From:
Sent: 13 August 2026 20:23
To: DC Admin
Subject: Planning application 2026/91900 – Supplementary
objection regarding access to No. 68
Attachments: file_000000003ab08246a3882d5115d97ca8.png
Categories:

Final Clarification and Evidence – Application 2026/91900

Existing Left Side Elevation
West 1:100

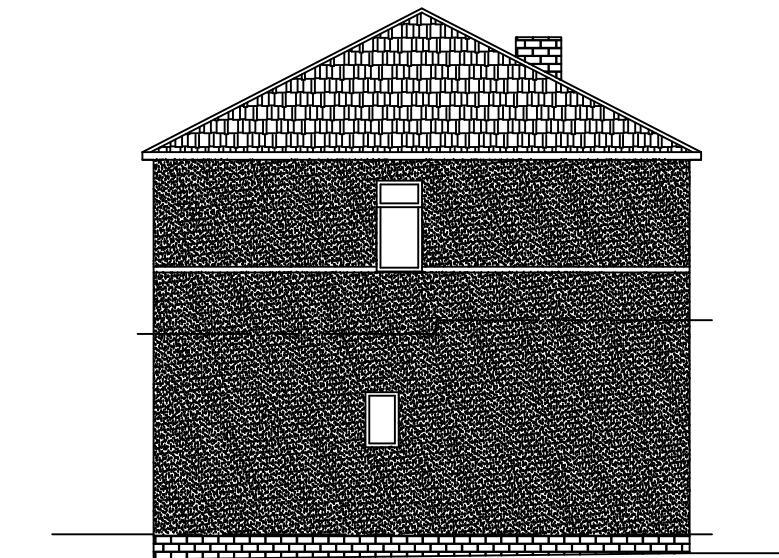
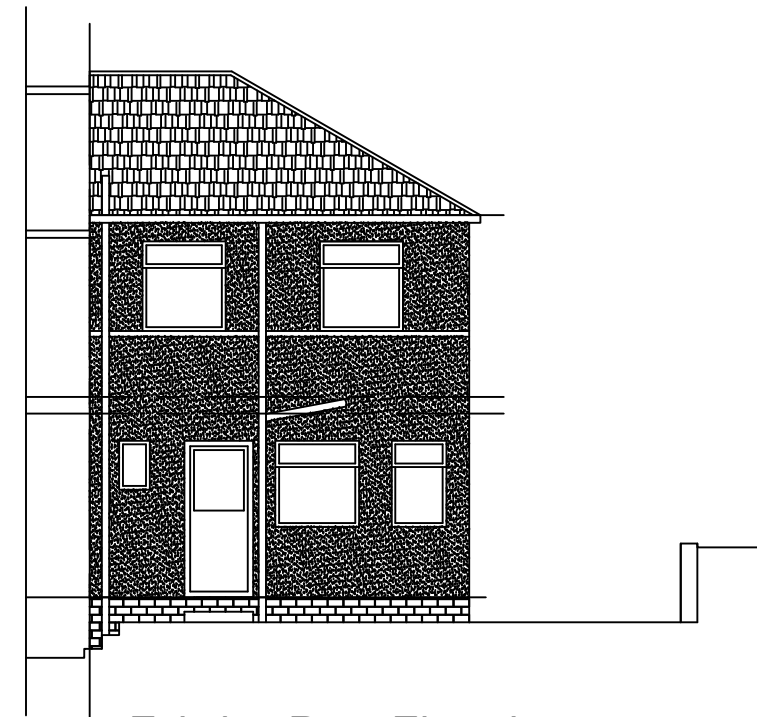
The site plan states "Access to be maintained for No. 68."
The extension as drawn would not maintain usable access.

Proposed Ground Floor Plan

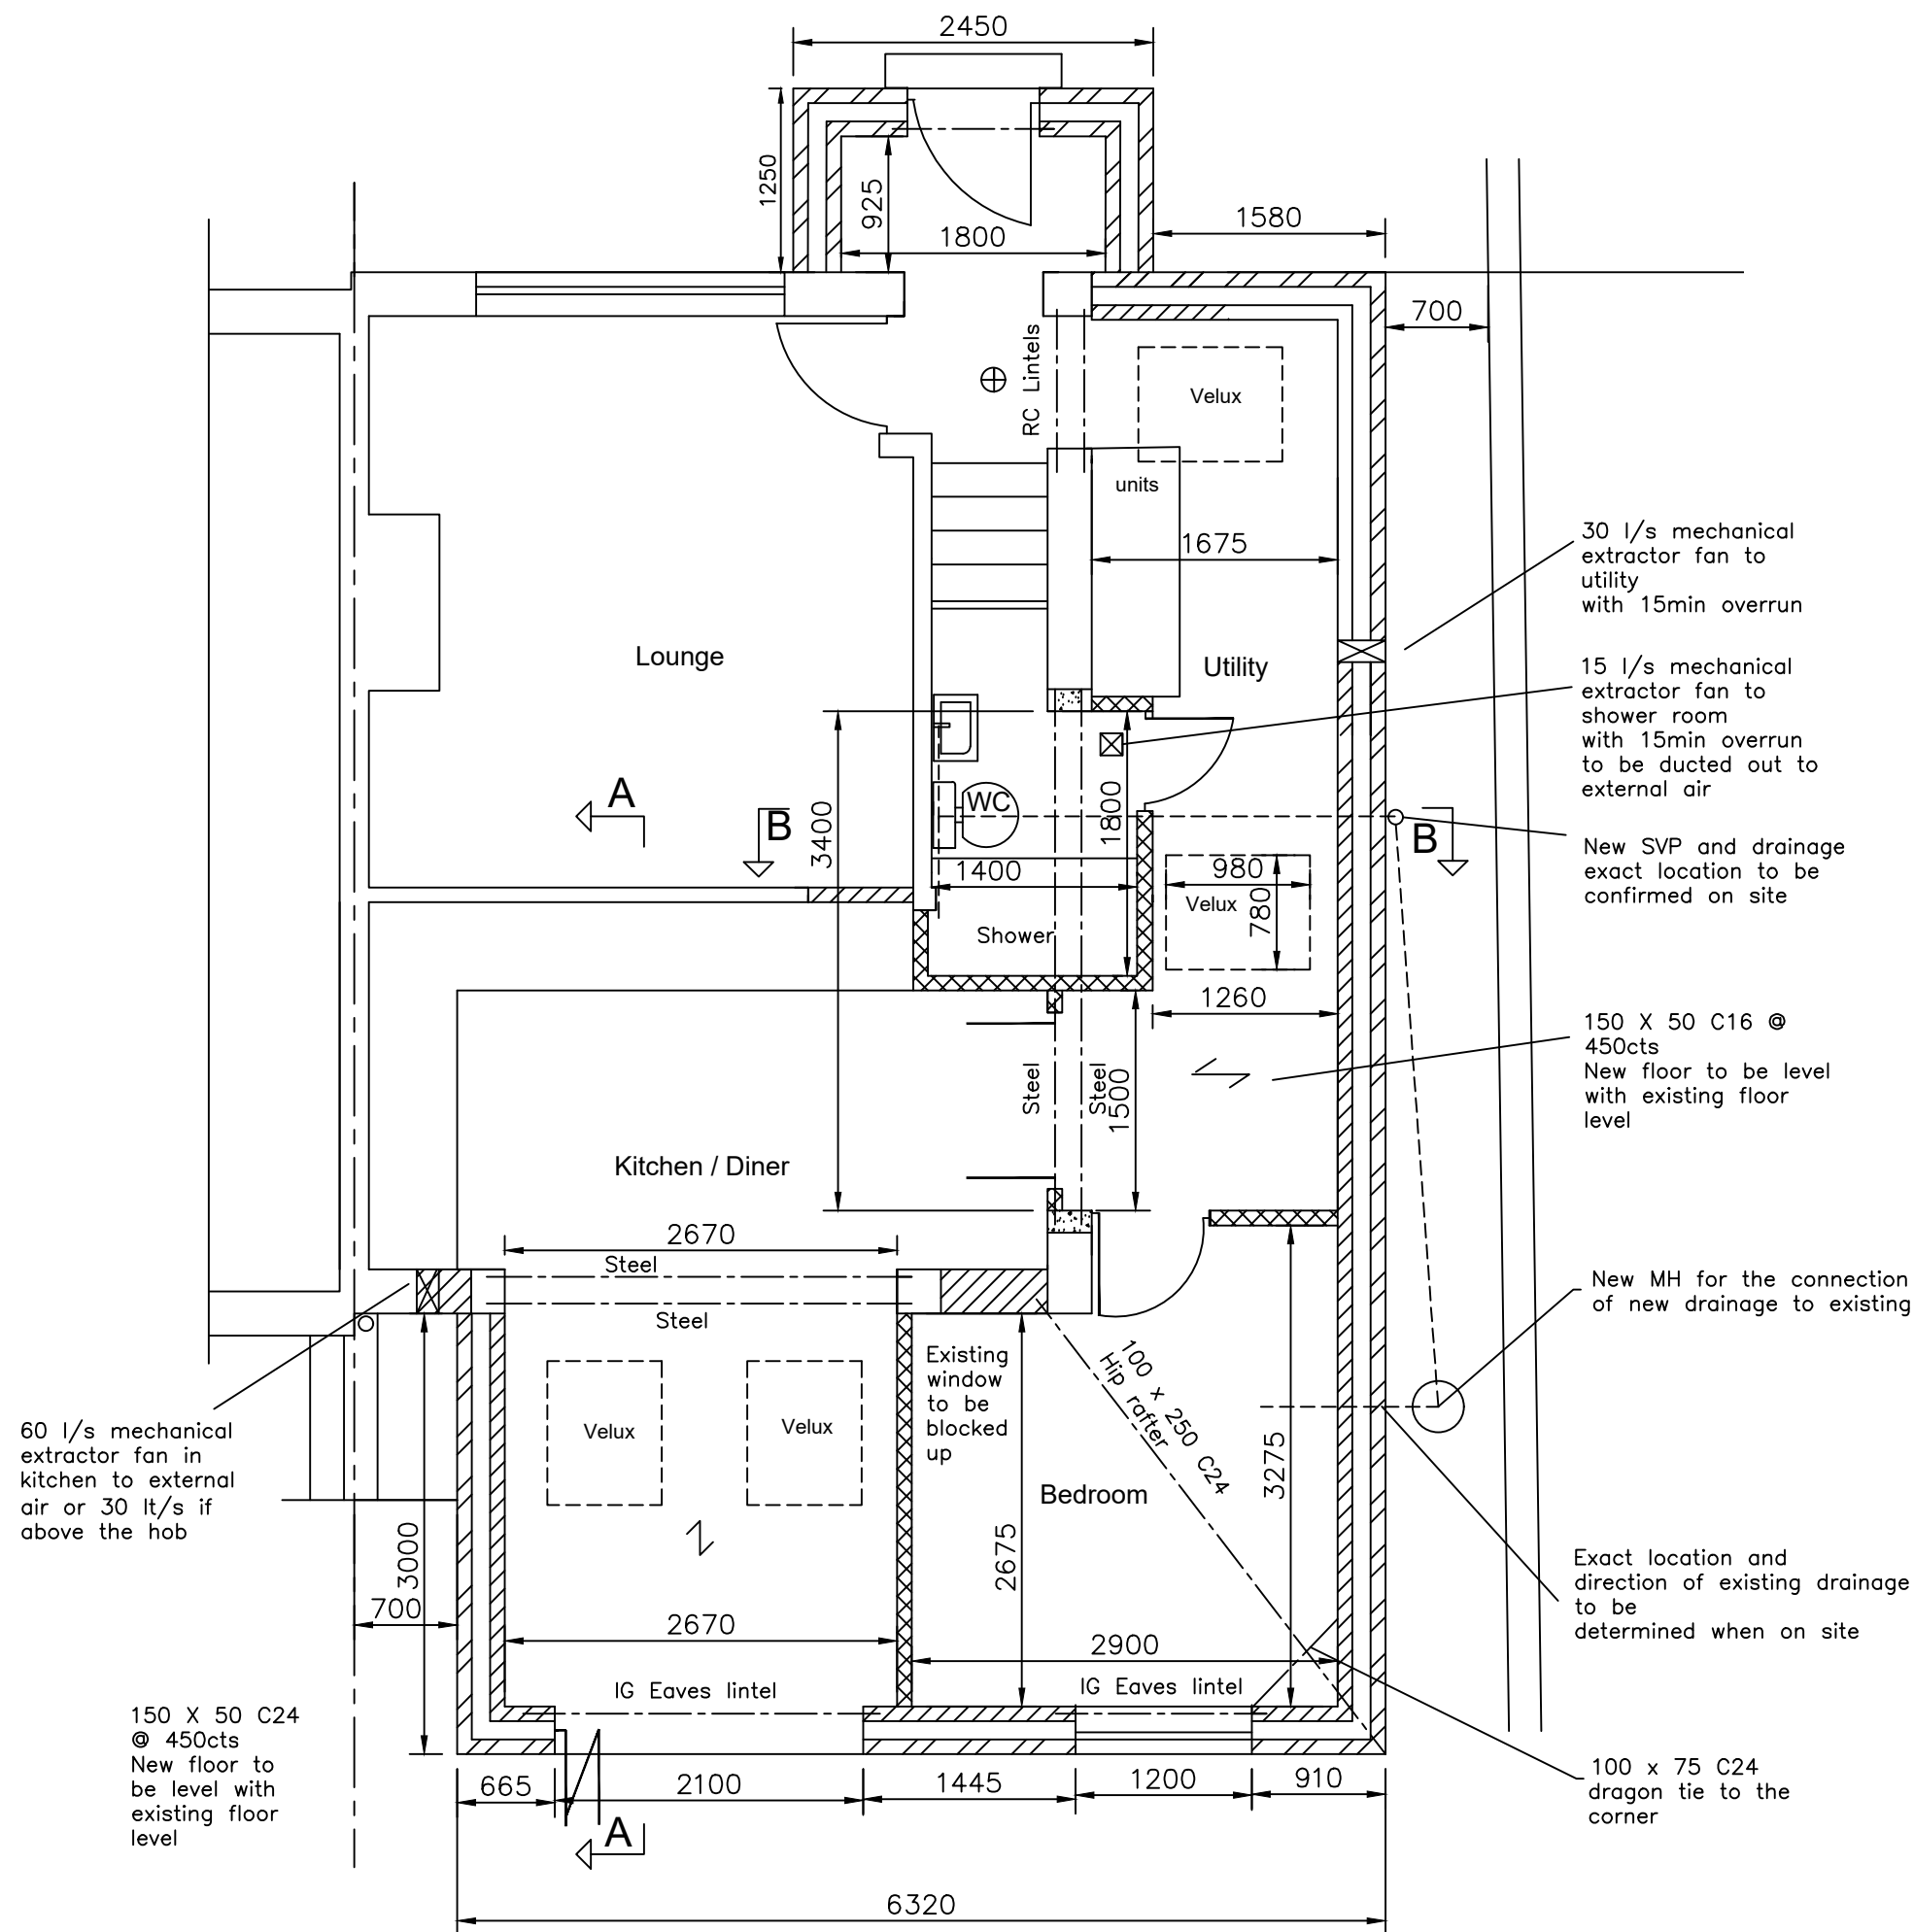
The plans also omit drainage details along this side passage, and they show a mechanical extractor fan positioned directly beside my only rear access point. Both issues have a direct effect on how I am able to use and maintain my property.

Because of these omissions, the 70 cm measurement on the drawing does not reflect the actual pinch-point, and I would be grateful if this could be considered when assessing the proposal.

Proposed Site Plan

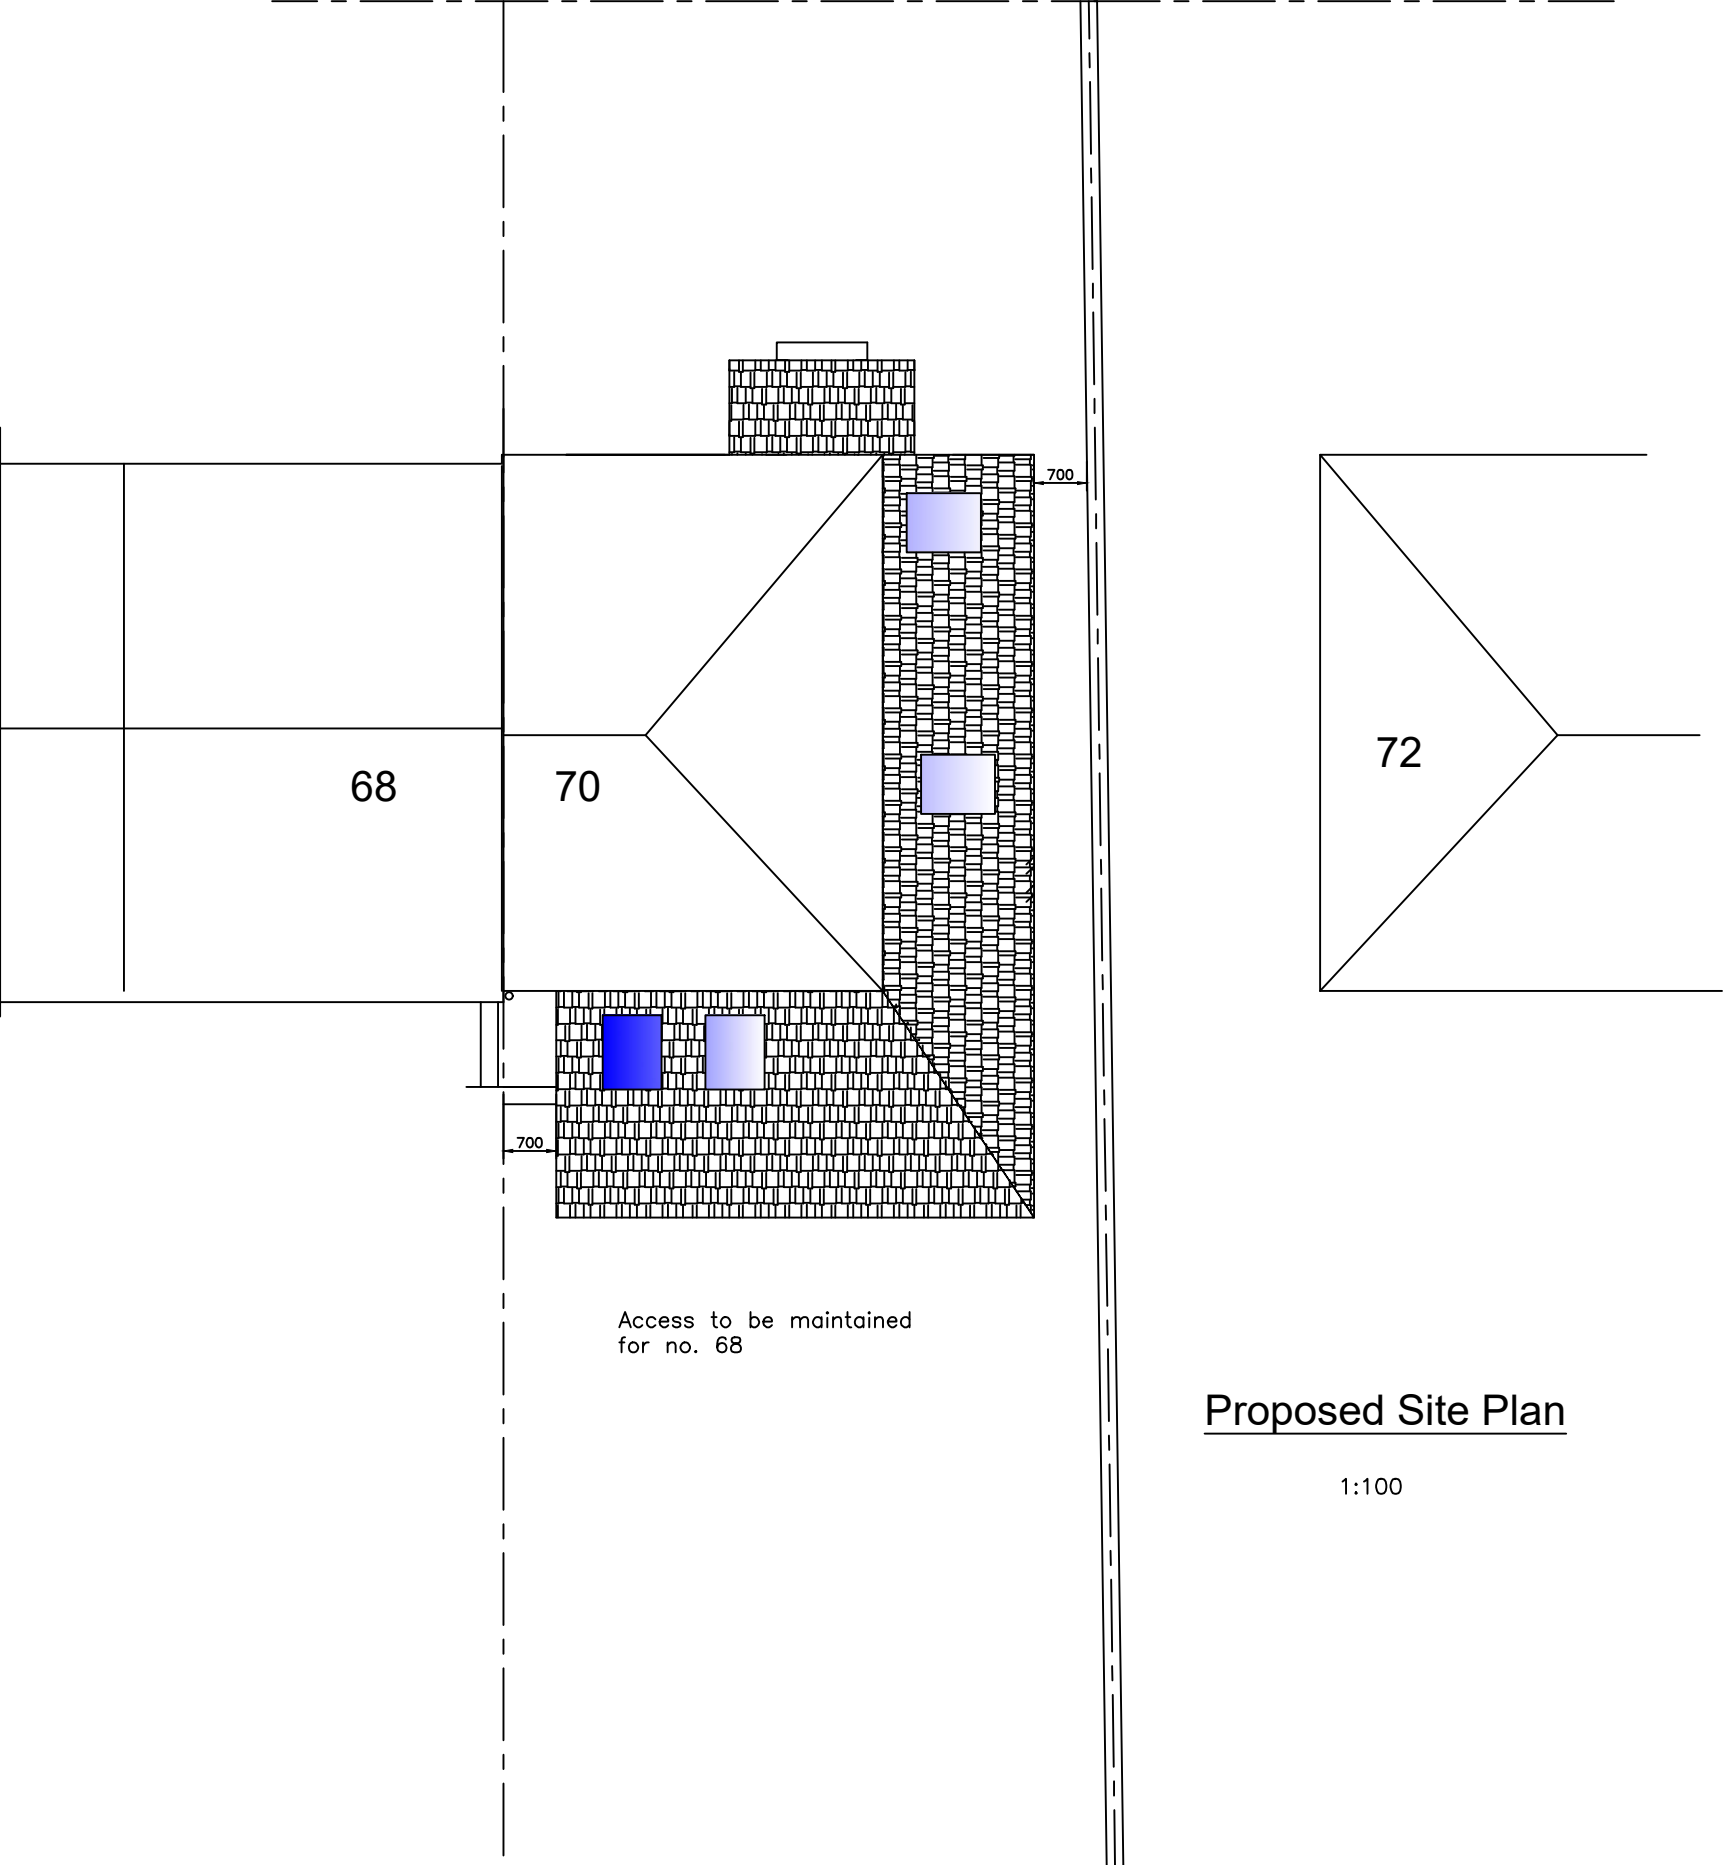
The applicant's stated 70 cm access width is not the usable width. The plans measure boundary-to-wall, but the actual usable width is reduced by several fixed physical features that are not shown on the drawings:

These features reduce the usable width to approximately less than 20–35 cm, which is not sufficient for access, maintenance, or safe passage. This is a material inaccuracy in the submitted plans.

Contradiction with site plan — “Access to be maintained for No. 68” cannot be achieved

The drawings measure a 70 cm gap from a straight boundary line, but this does not represent the actual usable width at my property. The real access route includes a recess, a level change, steps, a pipe, brickwork and a 90-degree turn, none of which are shown on the plans. These features significantly reduce the usable width at ground level, which is where access is required for maintenance and moving items.
